EPC STORMWATER REVIEW COMMENTS
IN ORANGE BOXES WITH BLACK TEXT

CITY LINK TRUCKING

Grading & Erosion Control Plans

PCD File # PPR2339

CIVIL DETAILS

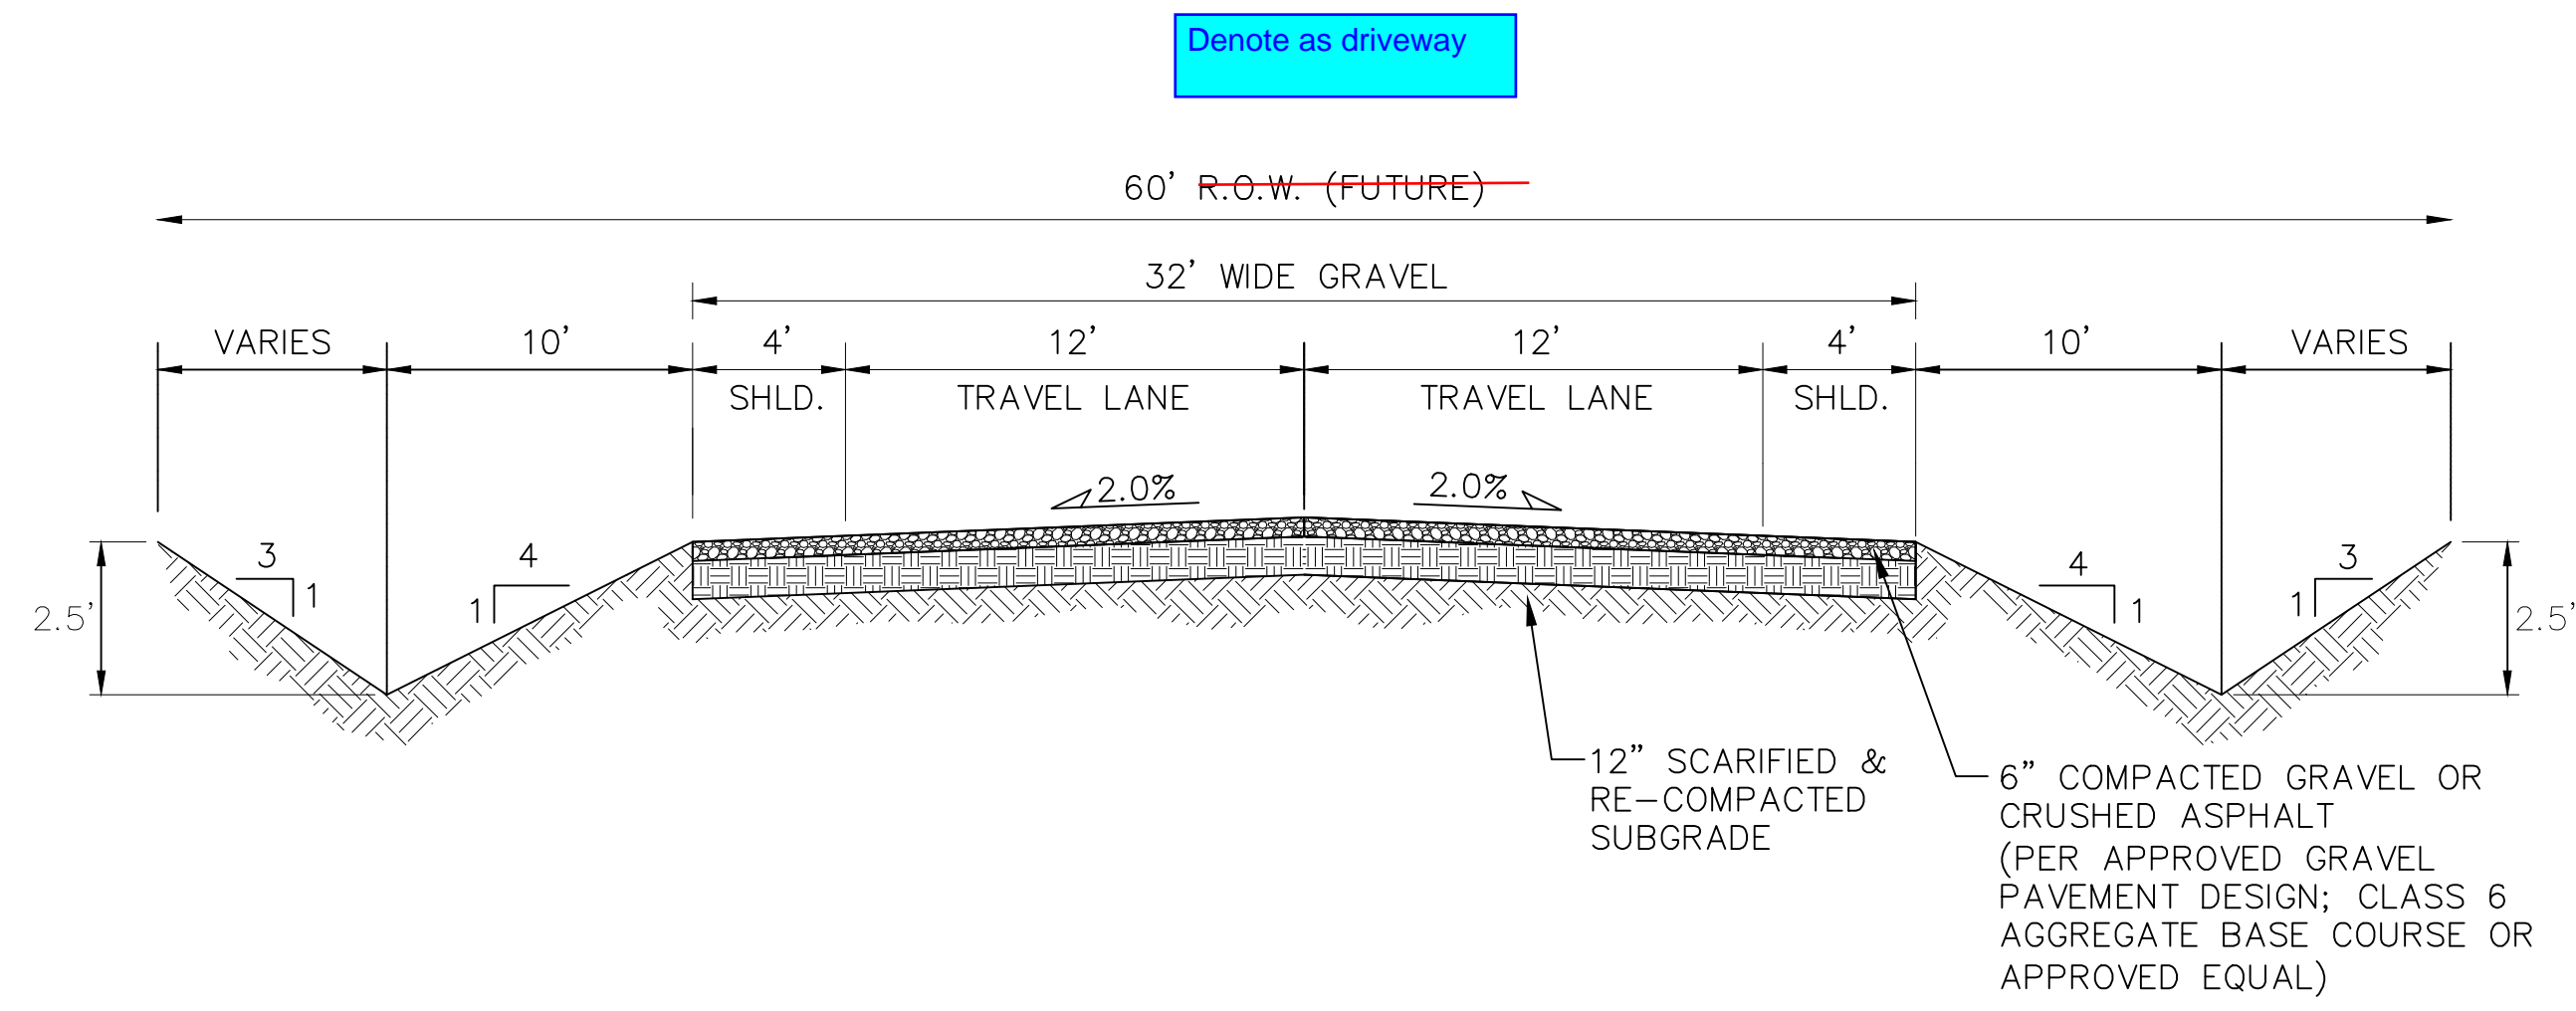
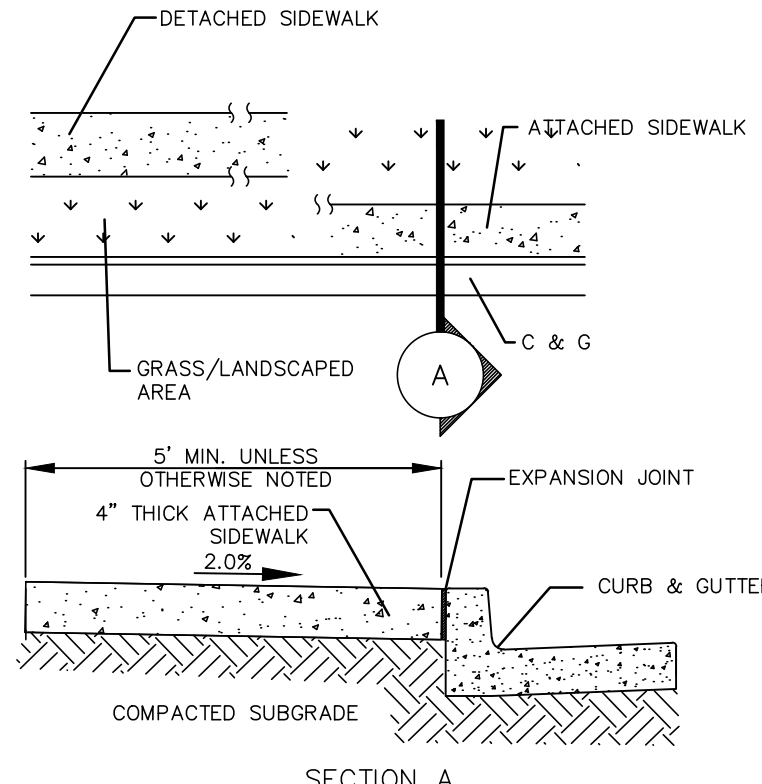
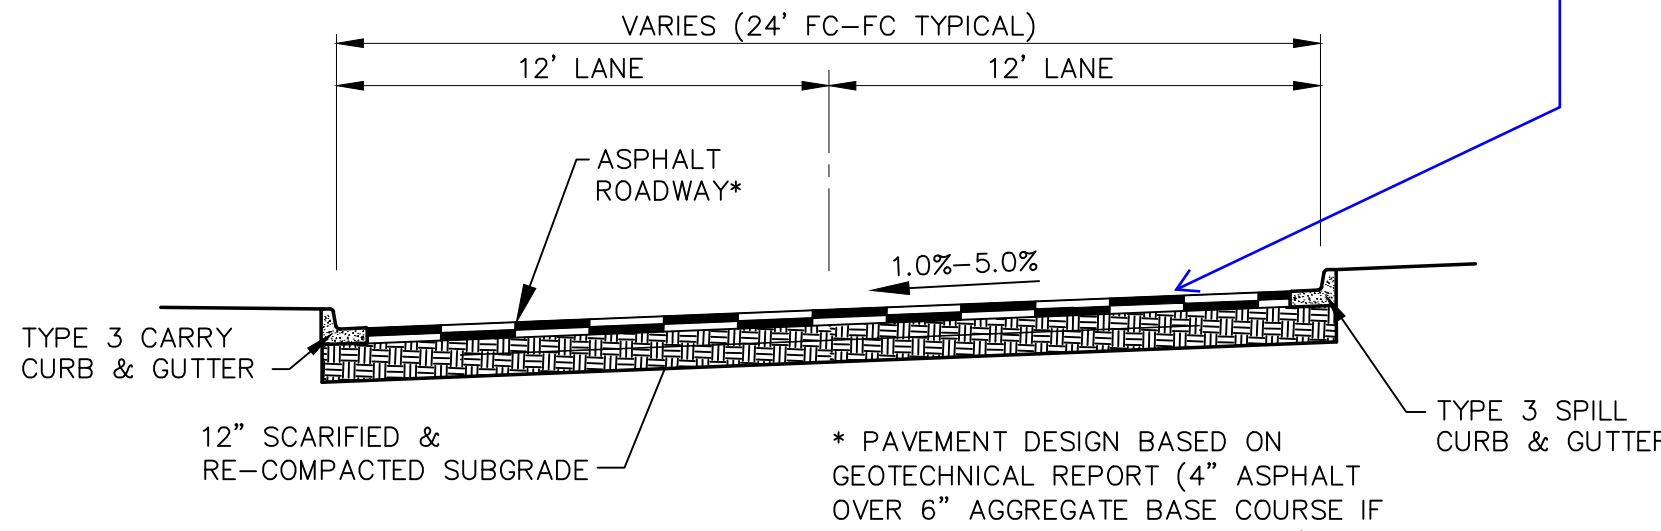
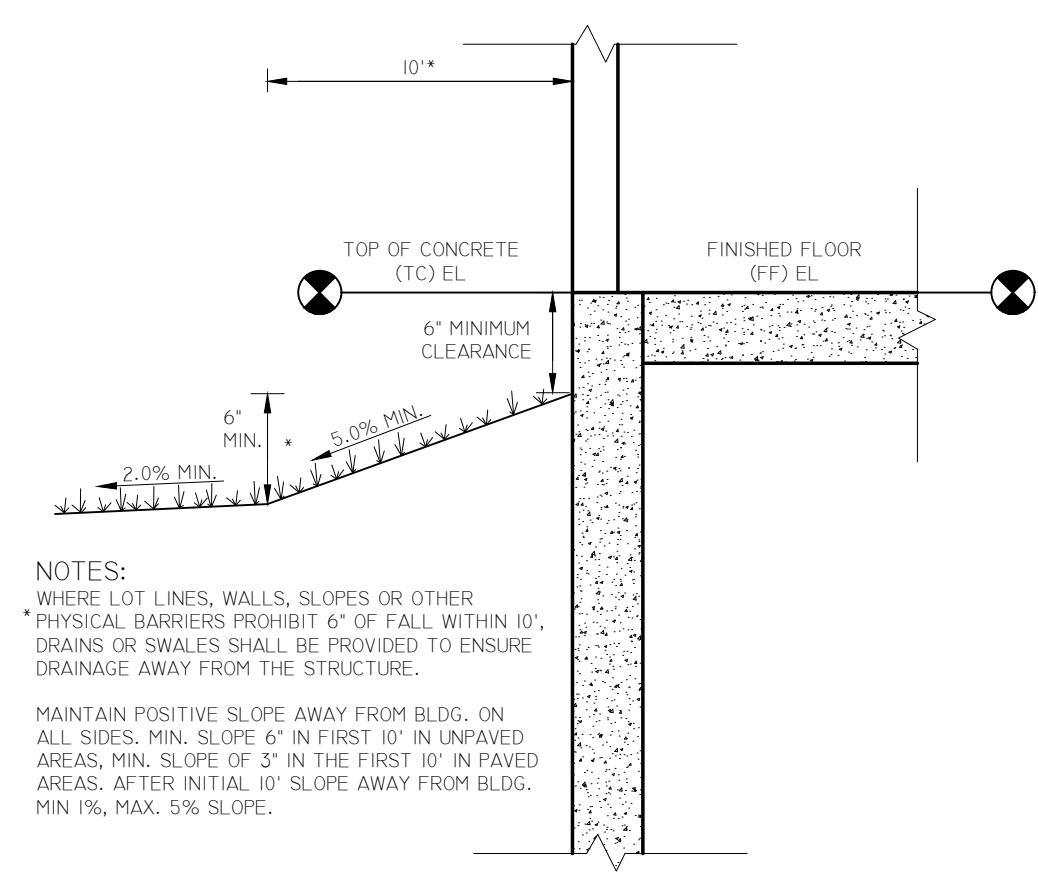
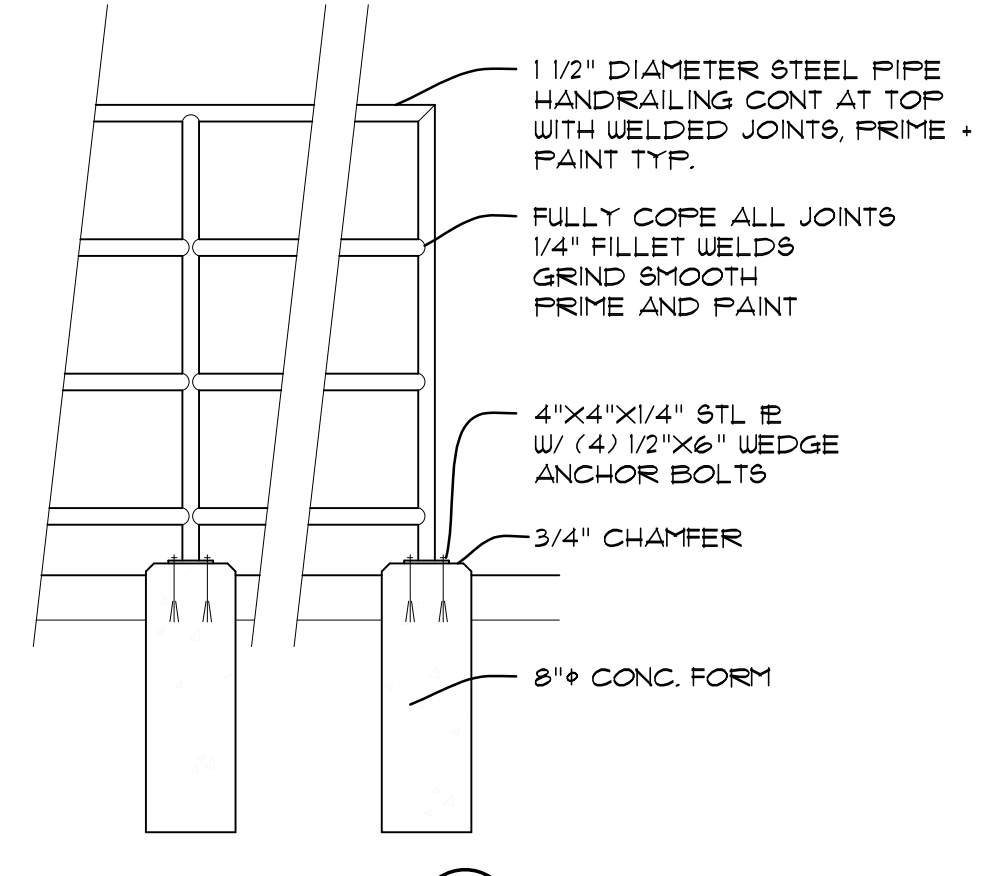
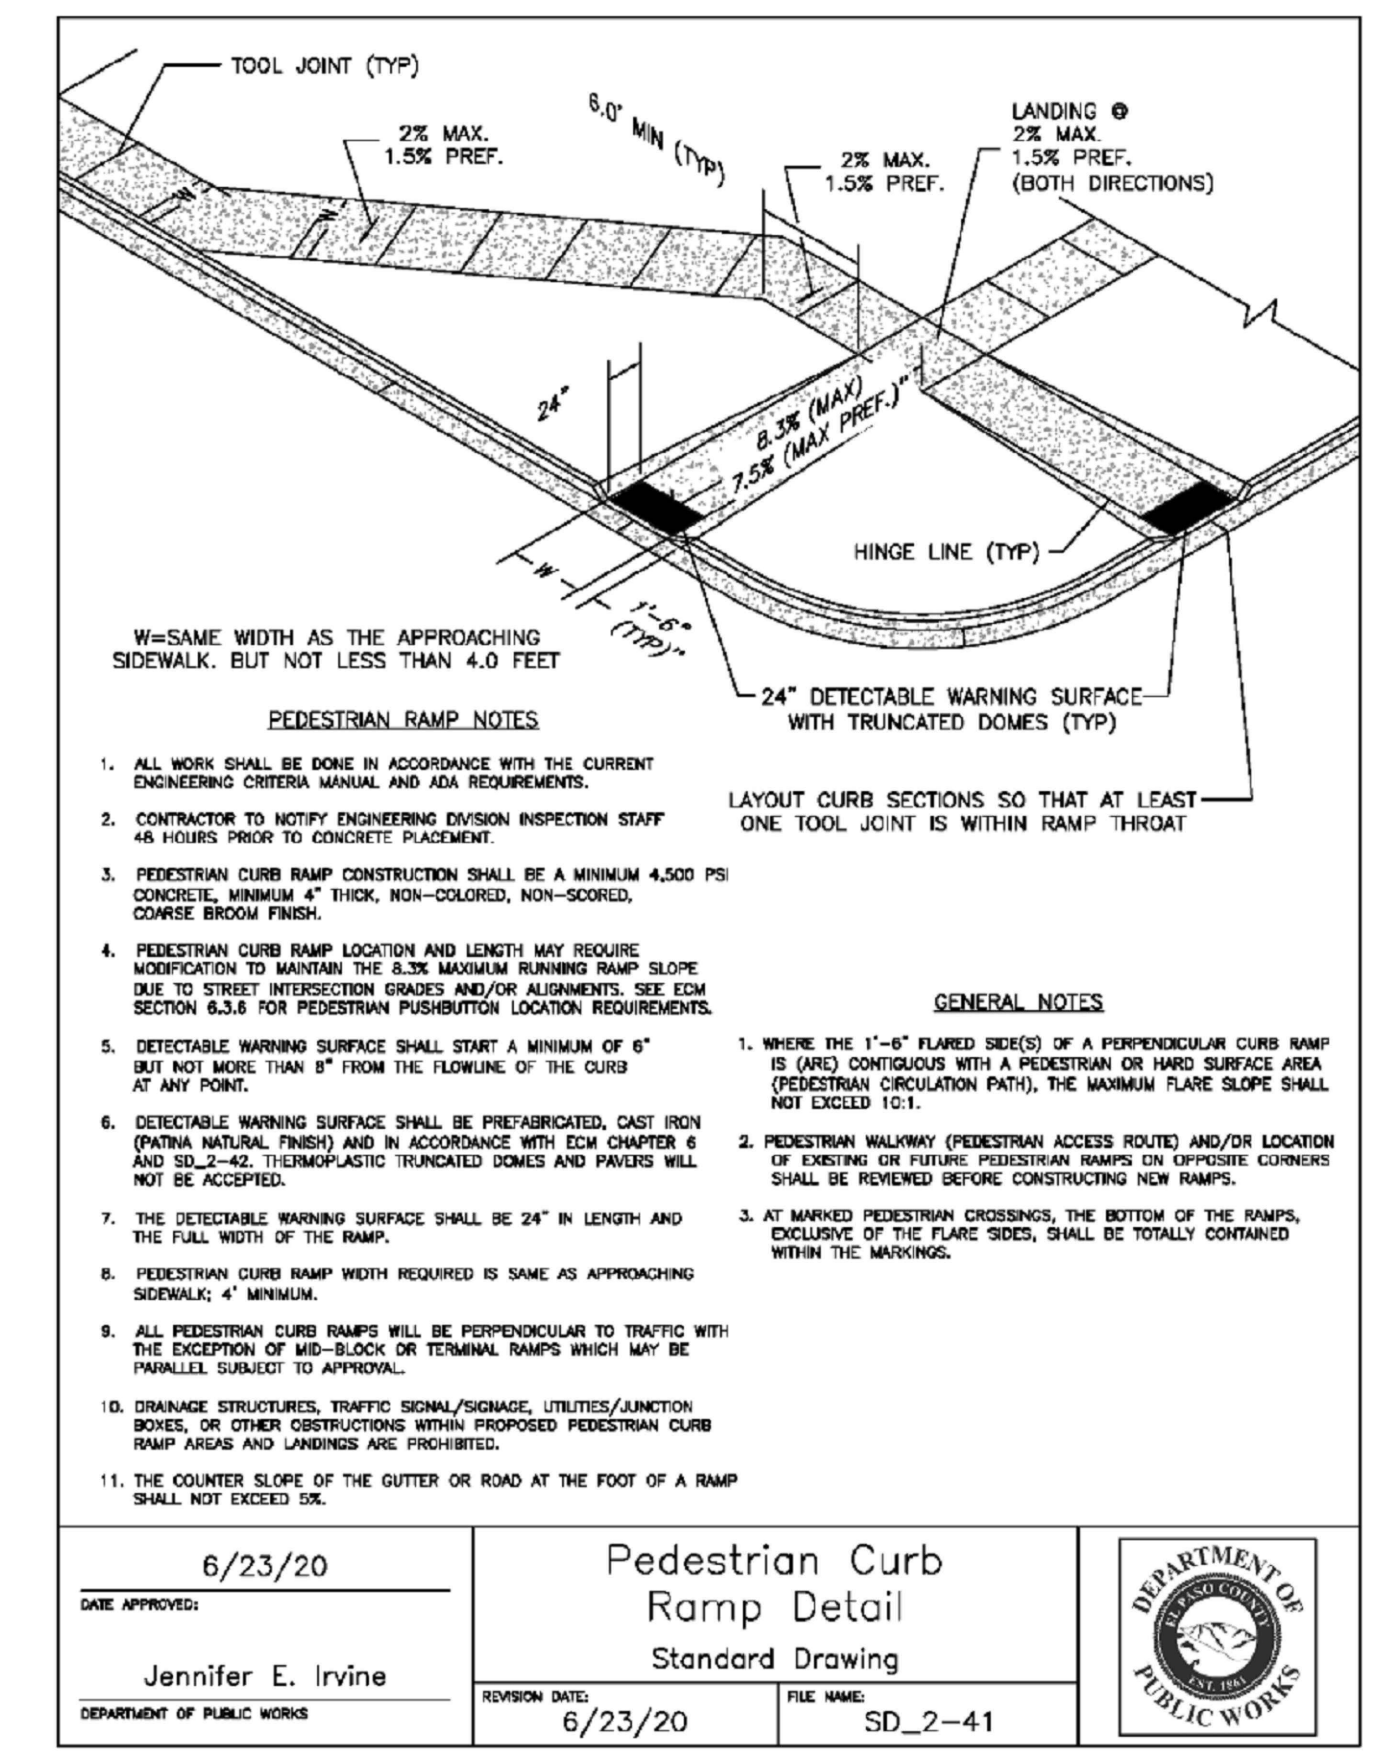
Call out on plans if not applicable then remove

No right of way is being platted. If this is how the driveway will be constructed then just label as private driveway design detail

Is a private driveway or private road being constructed? Please clarify in the LOI if a private road is being built

Where are these on the site plan? Please call out or remove if not applicable
